The Secretary
NSW Planning, Industry & Environment

10 December 2019

I refer to the Department's below email of 8 November 2019 regarding State Significant Development SSD-9477 at O'Keefe Drive, Oran Park (Lot 1001 DP 1234527) for 'New Catherine Field Primary School. The development of a new public primary school to accommodate up to 1,000 students including 44 classrooms, a hall, an administration/staff centre, library resource centre, amenities and storage, staff car parking and site services'. Submissions need to be made to the Department by 11 December 2019.

SITE SERVICES LEGEND	
Number	Description
1	WASTE PAD
2	MAIN SWITCHBOARD ROOM
3	SUBSTATION
4	PUMPS
5	SHADE STRUCTURE
6	PLANT WITH SCREEN
7	ASSEMBLY
8	BICYCLE PARKING
9	SPORTS FIELD
10	MAIN SCHOOL SIGN
11	FUTURE ELECTRIC SCHOOL SIGN

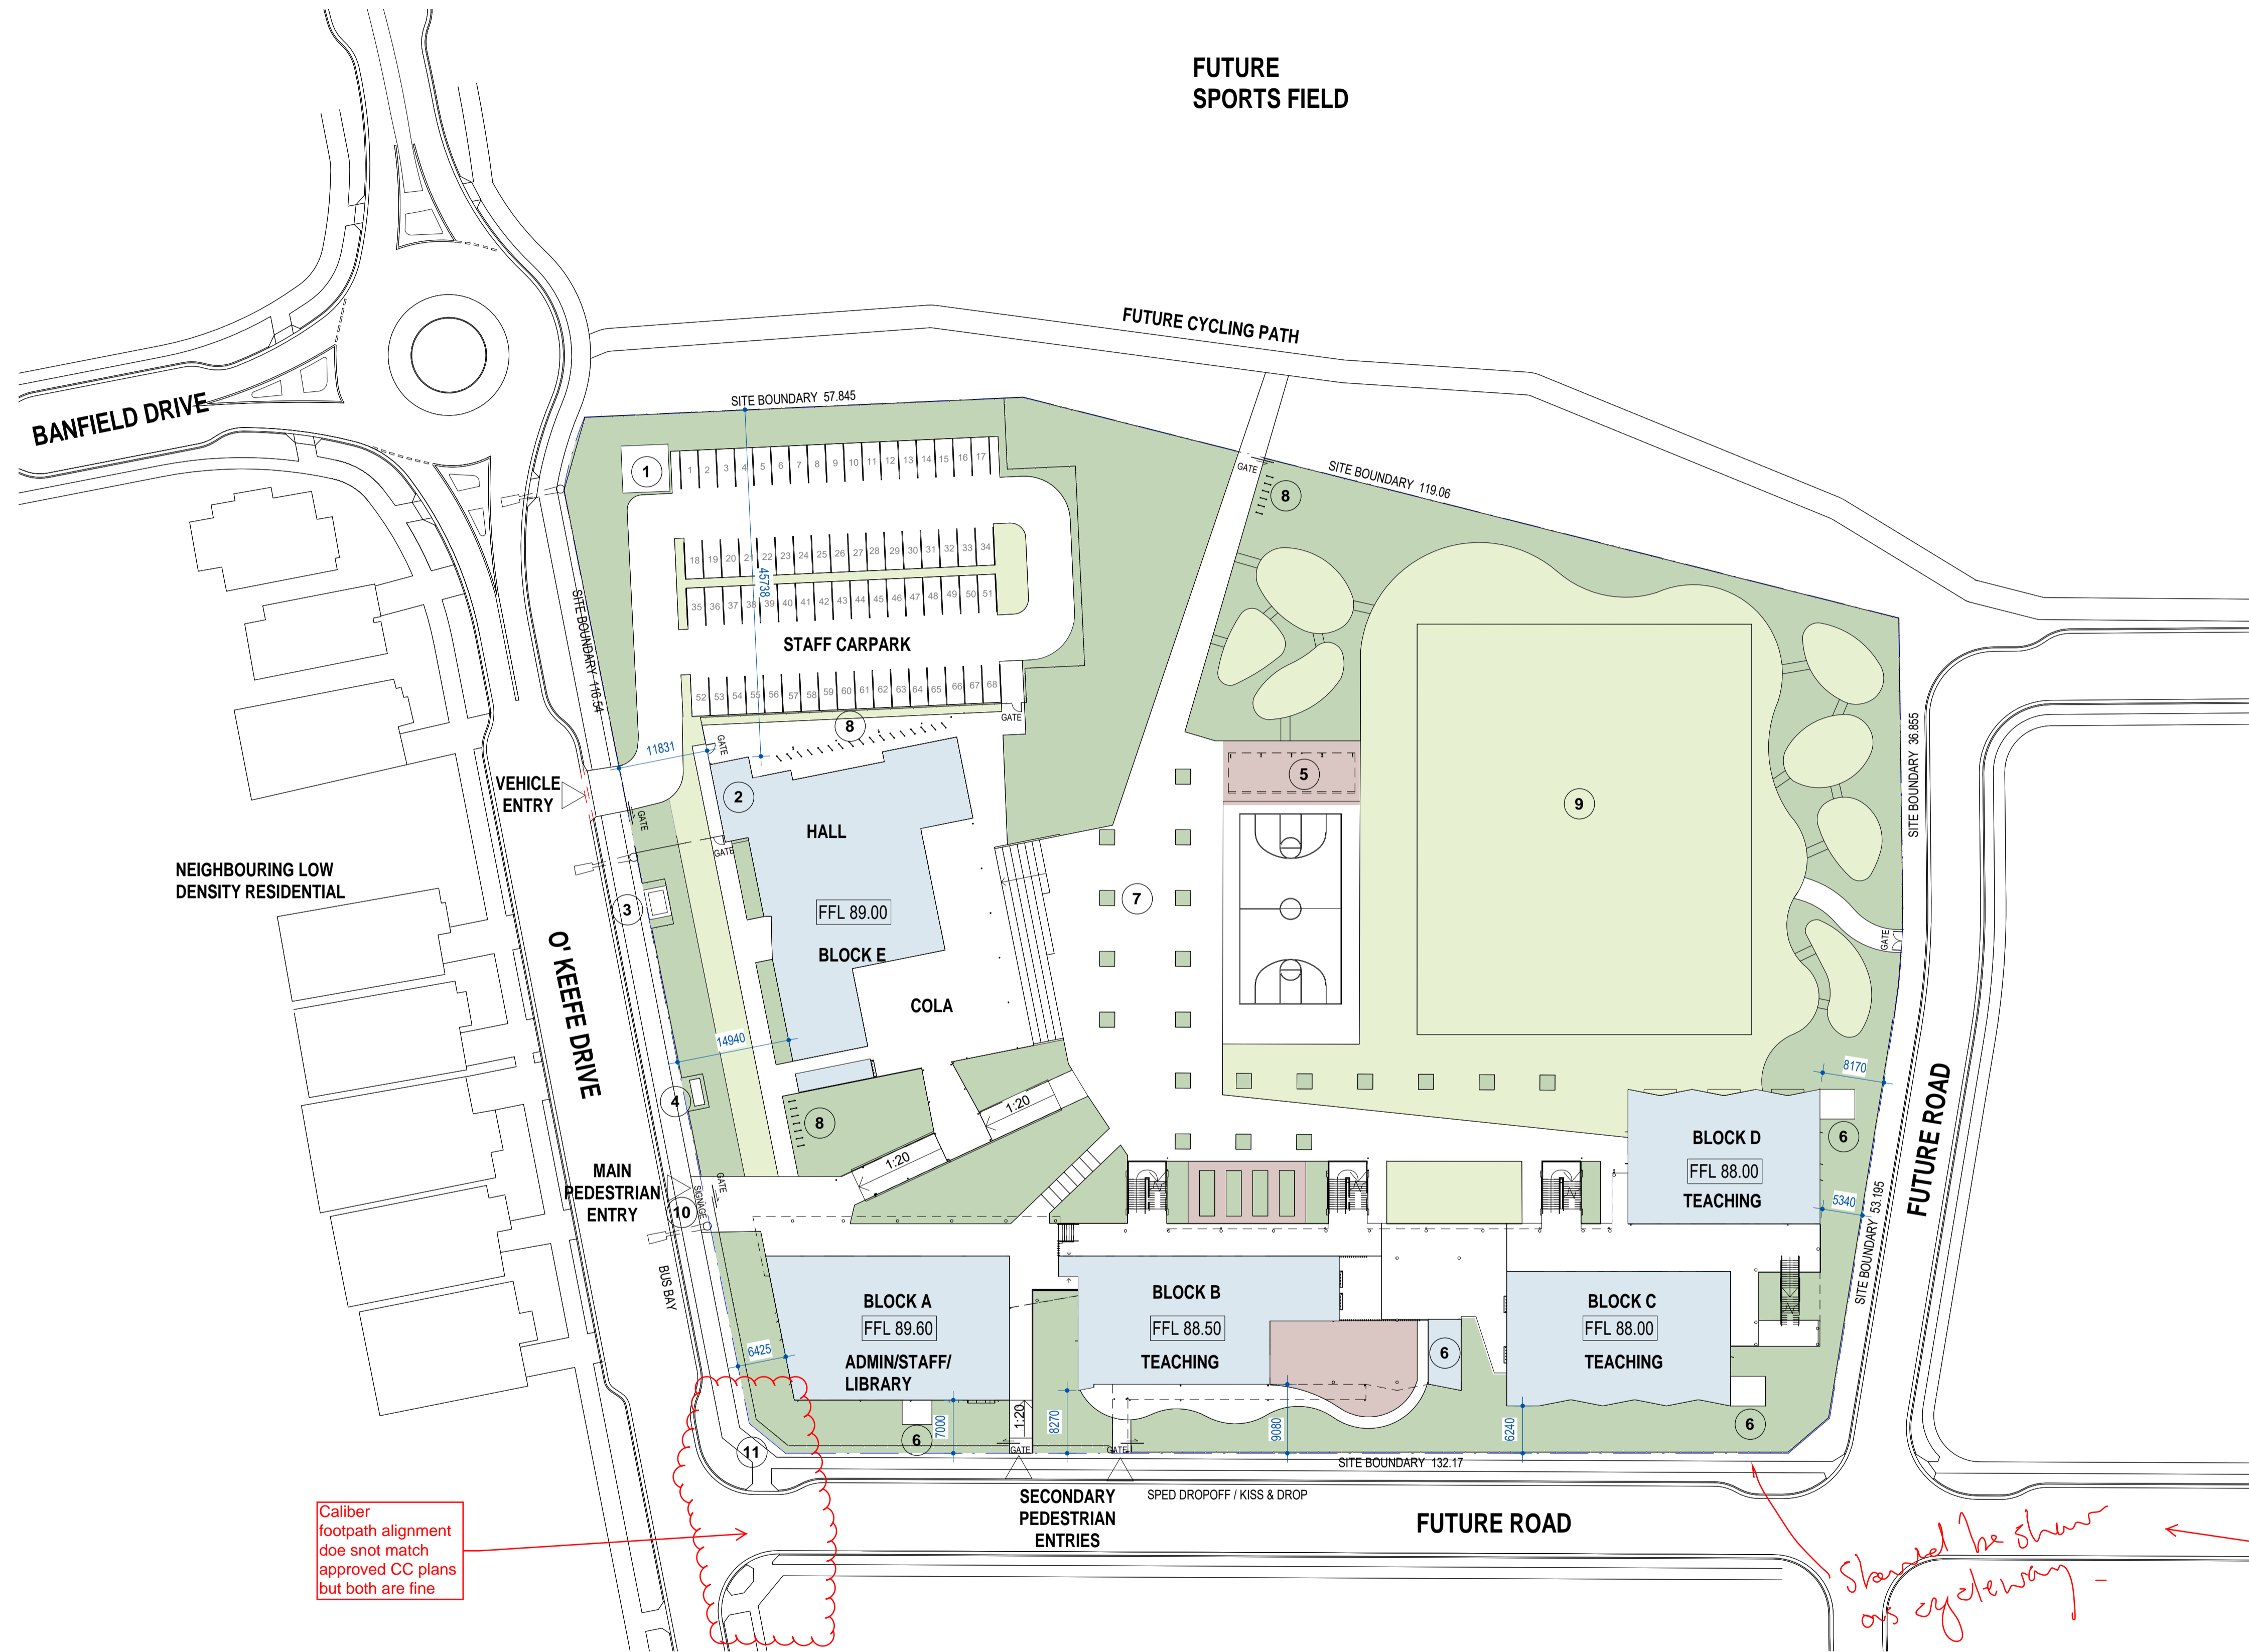
As indicated in the Infrastructure Management Plan, a padmount substation will be required to facilitate the construction of the new school. There are currently no 11 kV high voltage underground feeders in the locality of the padmount substation shown in the Proposed Architectural Plans and these would need to be extended to the proposed substation site to provide supply.

From Endeavour Energy's perspective the fact that provision is being made for the substation is a positive. Endeavour Energy's general requirements is for a padmount substation to be at ground level and have direct access from a public street (unless provided with a suitable easement for right of access). It must be protected (including any associated cabling) by an easement and associated restrictions benefiting and gifted to Endeavour Energy as outlined in the attached copy of Endeavour Energy's Mains Design Instruction MDI 0044 'Easements and Property Tenure Rights'.

The padmount substation easement has a minimum size of 2.75 x 5.5 metres and must also have the additional restrictions for fire rating (which usually extends 3 metres horizontally from the base of the substation footing, and 6 metres vertically from the same point and also has regard to any structures etc. attached to the building that may spread a fire) and possibly swimming pools and spas (which extends five meters from the easement but in this instance does not appear to be applicable).

Generally it is the Level 3 Accredited Service Provider's (ASP) responsibility (engaged by the developer) to make sure that the substation location and design complies with Endeavour Energy's standards the suitability of access, safety clearances, fire ratings, flooding etc. As a condition of the Development Application consent the Department should request the submission of documentary evidence from Endeavour Energy confirming that satisfactory arrangements have been made for the connection of electricity and the design requirements for the substation, prior to the release of the Construction Certificate / commencement of works.
